From: David Innes
Sent: 22 March 2017 09:44
To: Planning.Responses
Subject: FW: Pagham South P/140/16/OUT

From: Ian Gledhill
Sent: 21 March 2017 10:16
To: [REDACTED]
Cc: [REDACTED]
Subject: RE: Pagham South P/140/16/OUT

Hello Fiona, thanks for the additional information. I'd ask that this is forwarded to the Local Planning Authority so this can be placed on the public planning file. For ease of reference for my response here, I've stuck to those outstanding points from my formal consultation response.

Figure 5.2 – Proposed northern site access junction

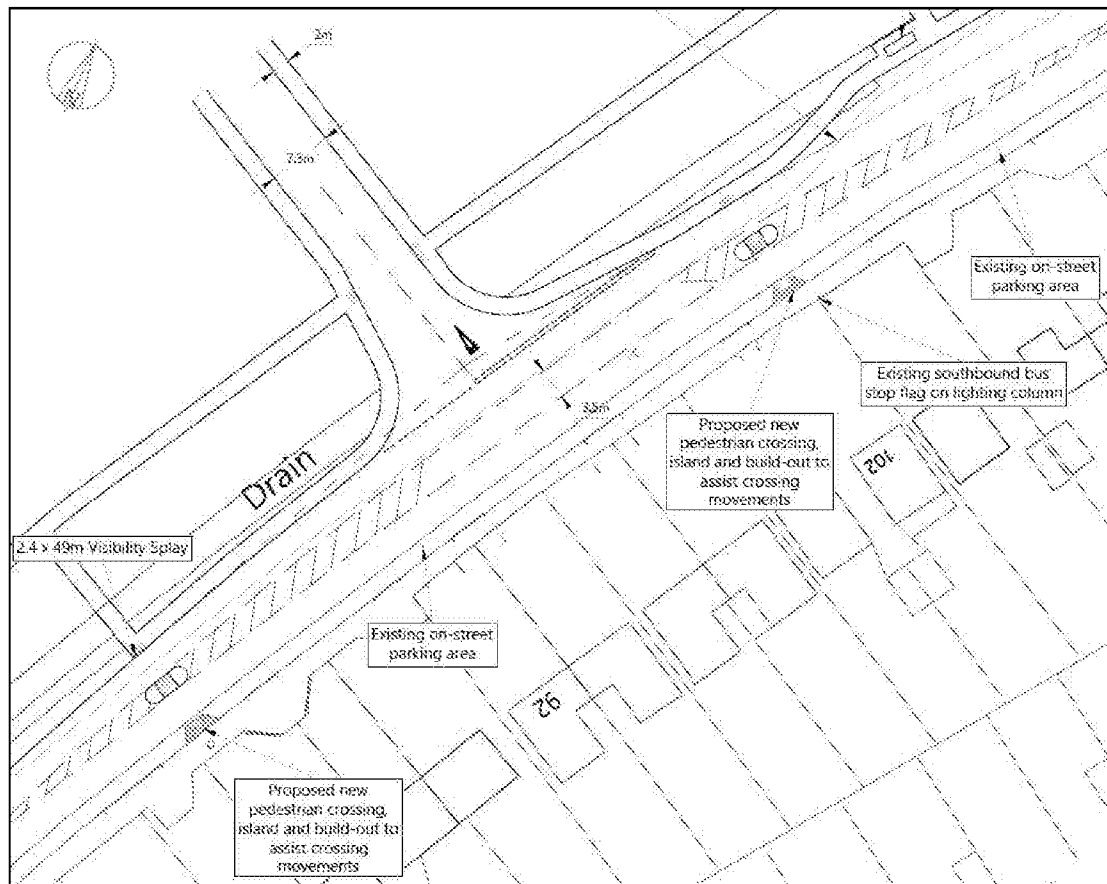
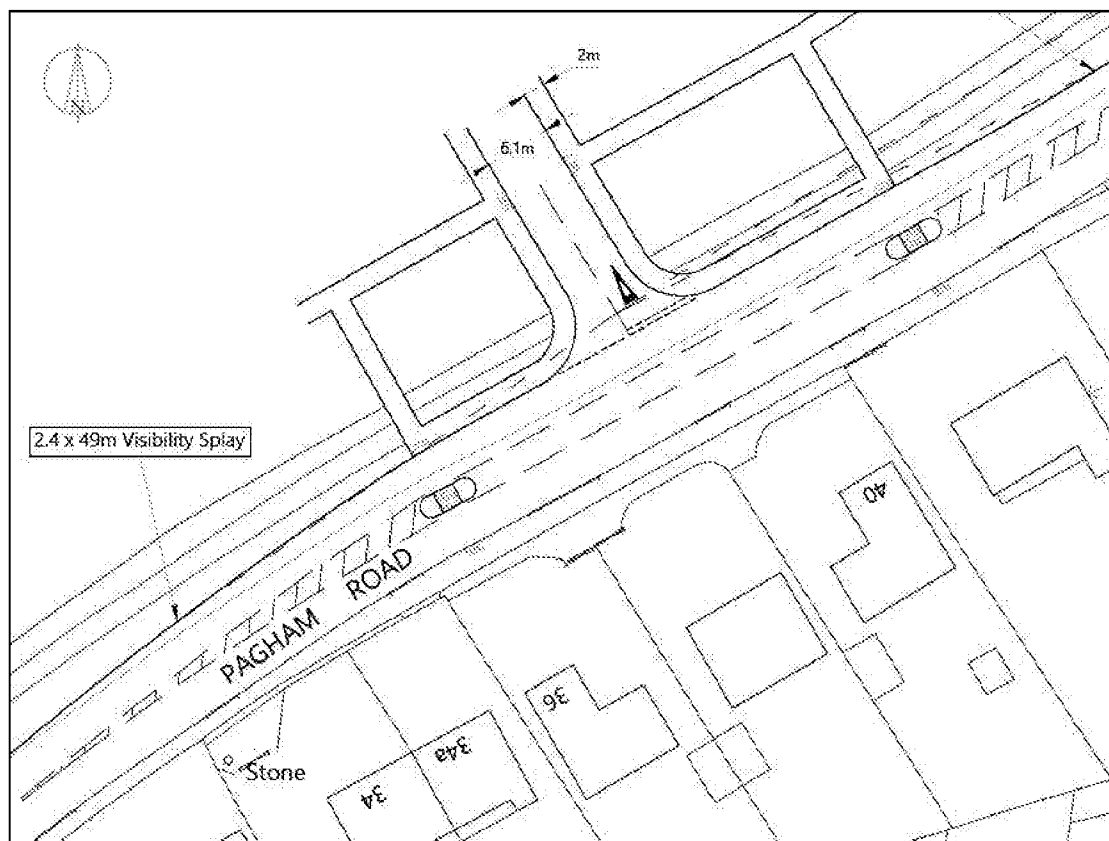
In terms of more detailed matters, the pedestrian refuges have been widened to 2 metres. Kerb to kerb carriageway widths alongside these refuges exceed the required WSCC minimum widths of 3.5 metres. Where necessary at the northern access, build outs are included to ensure that pedestrians do not cross between parked cars. A further pedestrian crossing point is provided on the southern side of the access to the Parish Council's car park along with a build out on the opposite side of the carriageway. The build out lies immediately adjacent to a residential access. Although the tracking drawings (which is based on OS data rather than a topographical survey) indicates that a standard vehicle could turn into the residential access, in practice given the close vicinity of the build out to the access, it would be more desirable to extend the footway on the northern side of the carriageway and relocate the crossing further north (for example to the immediate east of the Parish Council car park access).

The access arrangements have been the subject of a Stage One Road Safety Audit. The majority of problems have been positively resolved. There are several problems that require further comment.

2.1.1 – The bus stop lay-by is understood to be the same dimensions as that already present. Providing it is demonstrated that a bus can stop entirely within this, the dimensions are accepted.

2.2.1 – Requires the provision of a central island to prevent overtaking within the hatched area at the bus stop. A traffic island has been provided. I have previously advised that the LHA have experienced issues with vehicles overtaking on the wrong side of traffic islands in order to pass a stopped bus. Having looked at this again, it is suggested that the traffic island is upgraded to a pedestrian refuge (this will then fulfil problem 2.3.1), and the matter of the vehicles overtaking buses considered as part of any Stage 3 Safety Audit once the works are in place. If issues do occur, a solution would be to relocate the bus stop rather than remove a crossing off a desire line.

Figure 5.4 – Link to Pagham Harbour cycle route

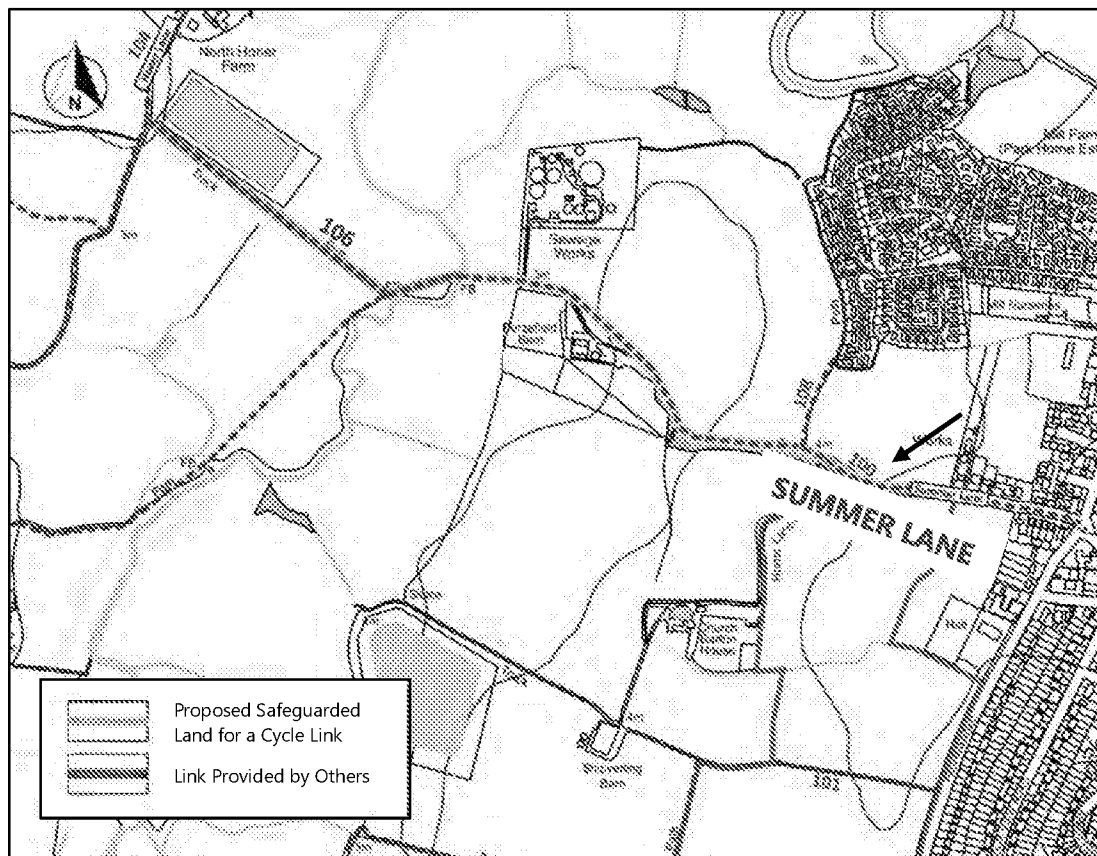
You will no doubt note the issue of the cycle link to the north. You will recall that in support of our application we are providing land that is within the clients control but outside the application site. Your previous comments related to the possibility of additional funding, and maybe this is something to be considered as part of the cumulative assessment work.

Figure 5.1 – Proposed mitigation at the Rose Green Road junction with Grosvenor Gardens

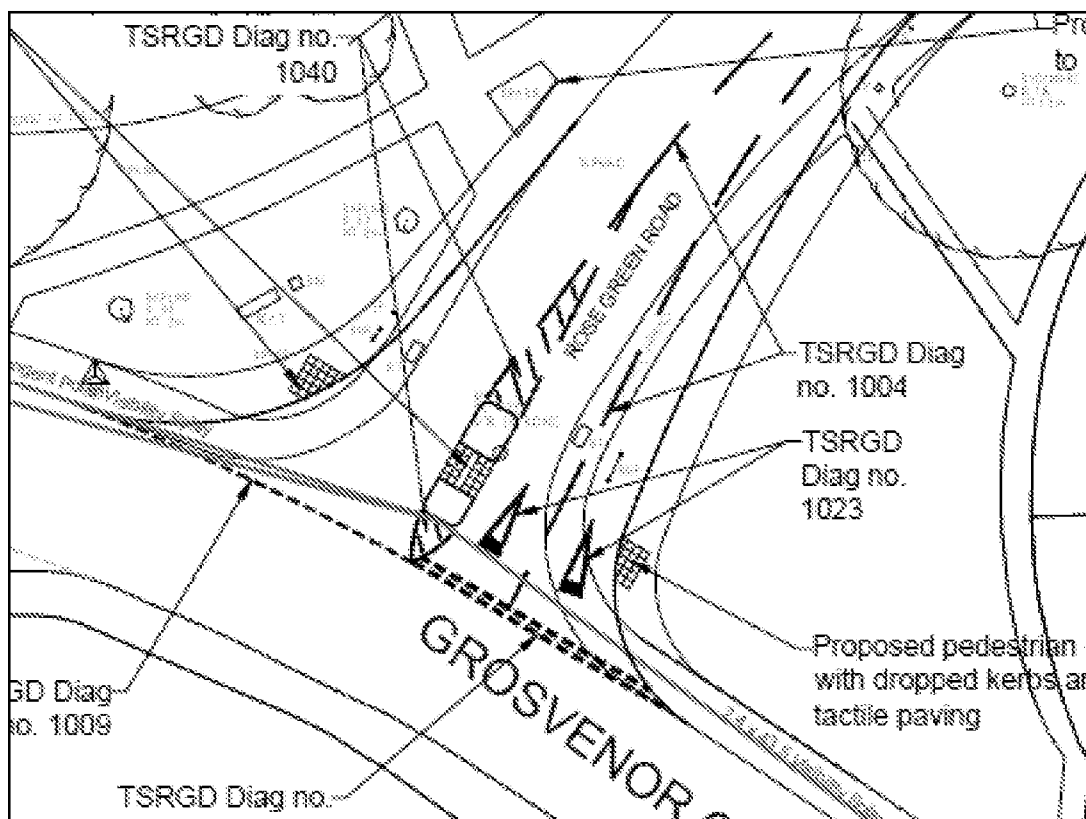
The only other matter that warrants further comment at this stage is the LinSig model used for the Gossamer Lane/Nyetimber Lane/Grosvenor Gardens junction. This still doesn't appear to include the pedestrian phases that are present on all arms.
